REF R/151/18/HH

Drawing N° 142 KF
Date 10-JUNE-2018
Scale 1:50
All measurements in mm

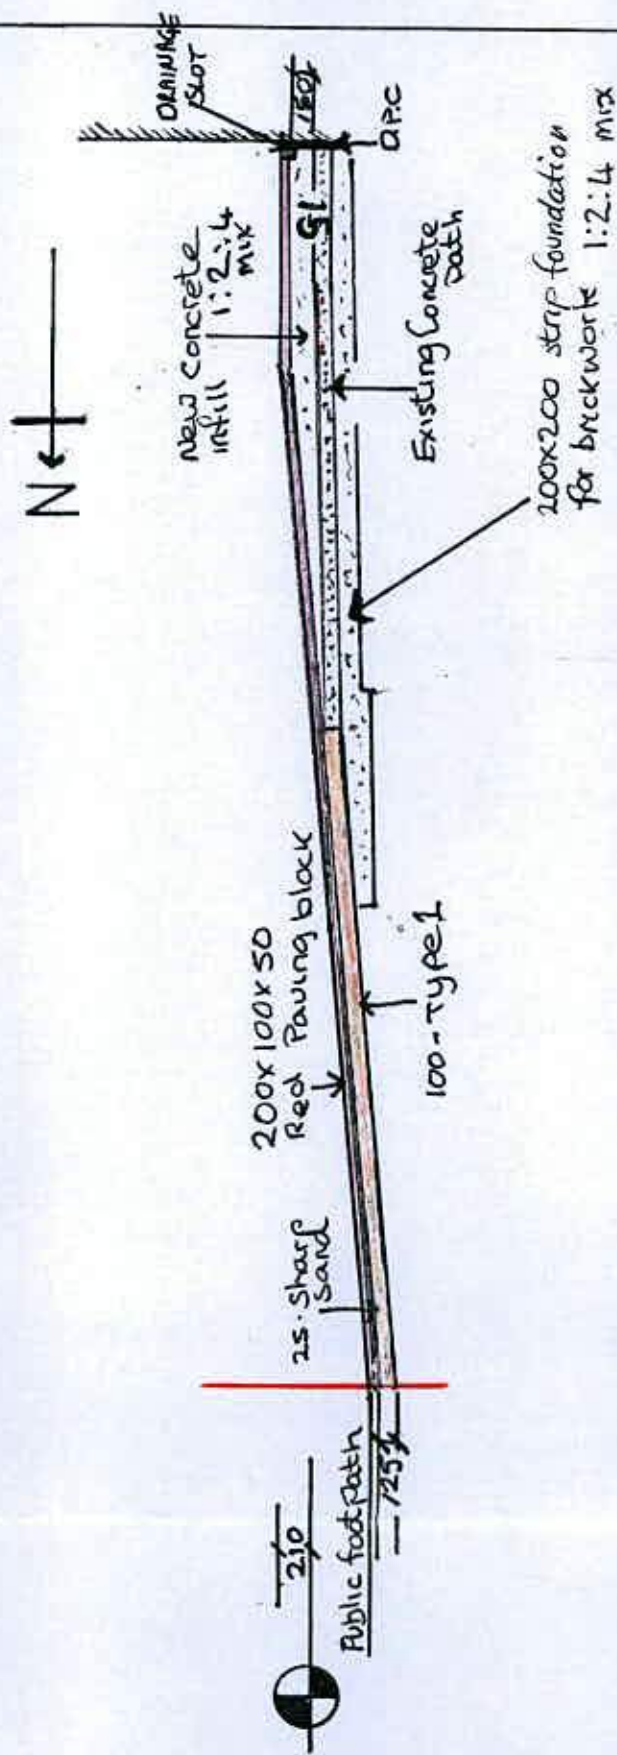
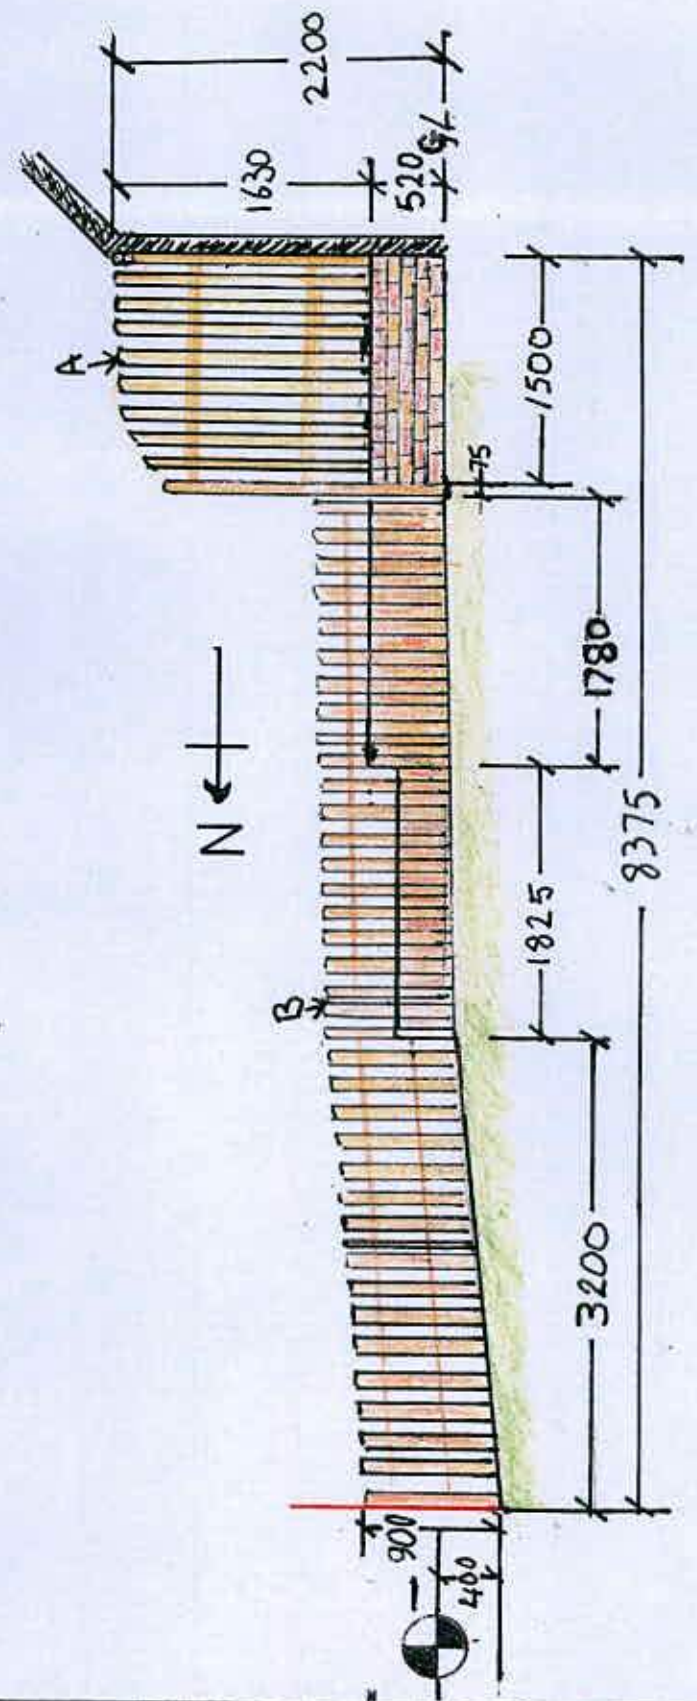
I strongly object to the unsightly over engineered raised pavement which is far too high and the seven foot fence built to divide the front porches boundary. This has apparently been built to disperse the fumes from our boiler. This is absolute nonsense; we have already sent proof to Mrs L Coney in your planning compliance division that these so called poisonous fumes are harmless. The raised footpath and seven foot high fence is right on the borderline of our property at no 16 and should not be allowed as this is a total disregard of the restriction R/7/75 put in place when the properties were built . Condition 9 of this states No Gate, Fence, Wall or other means of enclosure shall be erected or constructed forward of the buildings hereby permitted. I wish to complain in the strongest terms and request that the raised path, wall and fences be removed as soon as possible. This has been built illegally without consultation and without building permission. The builder and agent responsible for this work Mr

Paul Wood claimed he had contacted the planning department at Arun District Council who advised him that he could build a Ten Foot Fence down to the front of the garden if they wanted. Mr P Wood on behalf of Miss Faulkner has blatantly built these structures claiming that we could do nothing to stop them. The total disregard for the need to have planning permission is astonishing. The ridiculous suggestion of building a picket fence between No 16 and No 18 to keep us off their property is highly offensive. As we have not and will not be using their sterile gravel pathway, they have no need to put up yet another horrible structure. As to the fence already built between No 18 and No 20, it is an absolute insult, there is no rubbish.
